From: Thomas Callaway
Sent: 04 March 2015 15:27
To: Planning.Responses
Subject: RE: Planning Consultation on: LU/13/15/PL

Engineers comments in respect to surface water drainage:

APPLICATION NO: LU/13/15/PL

Description of Works: Demolition of original dairy distribution depot and construction of eight dwellings and ancillary works. This application may affect the character and appearance of the Littlehampton (East Street) Conservation Area.

SITE PLAN WITH DRAFT LEVELS + ROOF PLANS AS PROPOSED
PROPOSED RESIDENTIAL DEVELOPMENT
THE OLD DAIRY . CHURCH STREET . LITTLEHAMPTON . SUSSEX .
GRAHAM NICOLLS LIMITED . DESIGN + TECHNOLOGY . TEL / 07990 522709

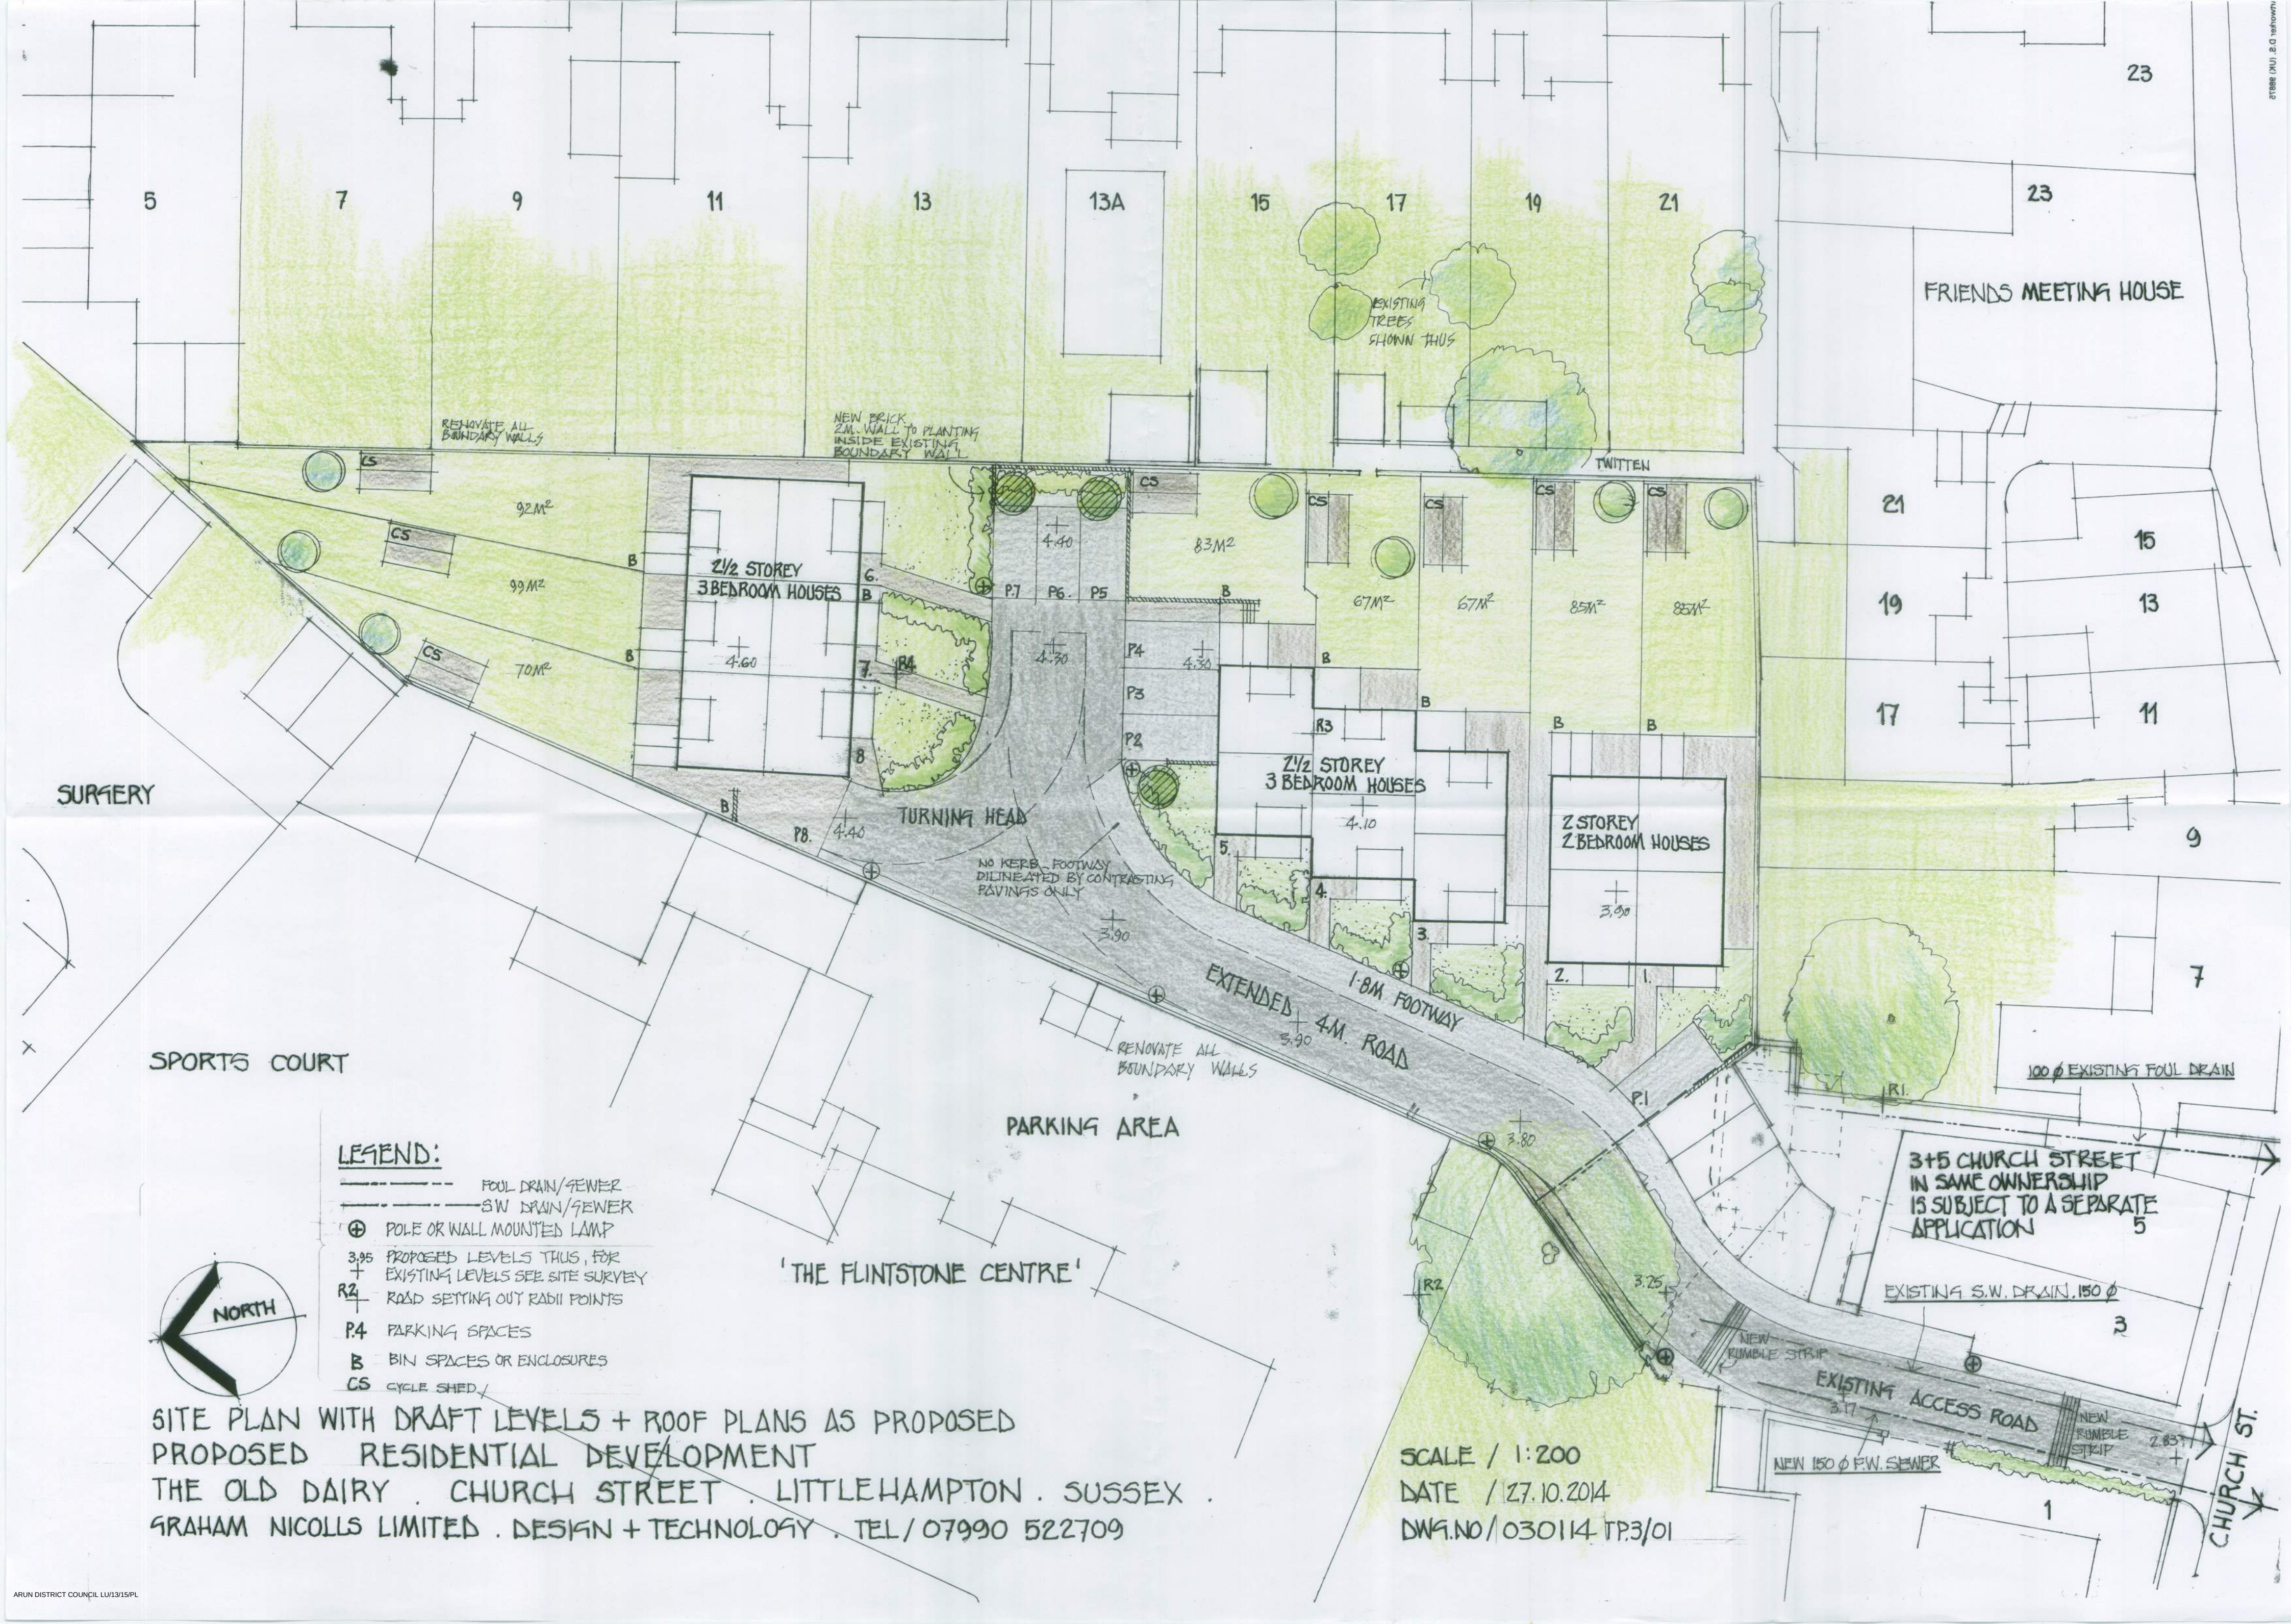
The applicant states that surface water will be allowed to infiltrate into the ground, using Sustainable Drainage Systems such as permeable paving. This should be prioritised over the original proposal stating that surface water will be disposed of through the main sewer, which should be avoided.

Infiltration rates for soakage structures are to be based on percolation tests undertaken in the winter period and at the location and depth of the proposed structures. The percolation tests and design must be carried out in accordance with BRE 365, CIRIA R156 or a similar approved method and cater for the 1 in 10 year storm between the invert of the entry pipe to the soakaway, and the base of the structure. It must also have provision to ensure that there is capacity in the system to contain below ground level the 1 in 100 year event plus 30% on stored volumes, as an allowance for climate change. Adequate freeboard must be provided between the base of the soakaway structure and the highest recorded annual groundwater level identified in that location.

Any SuDS or soakaway design must include adequate groundwater monitoring data to determine the highest winter groundwater table in support of the design. The applicant is advised to discuss the extent of groundwater monitoring with the Council's Engineers. Supplementary guidance notes are also enclosed for information.

Please apply standard conditions ENGD2A and ENGD5A.
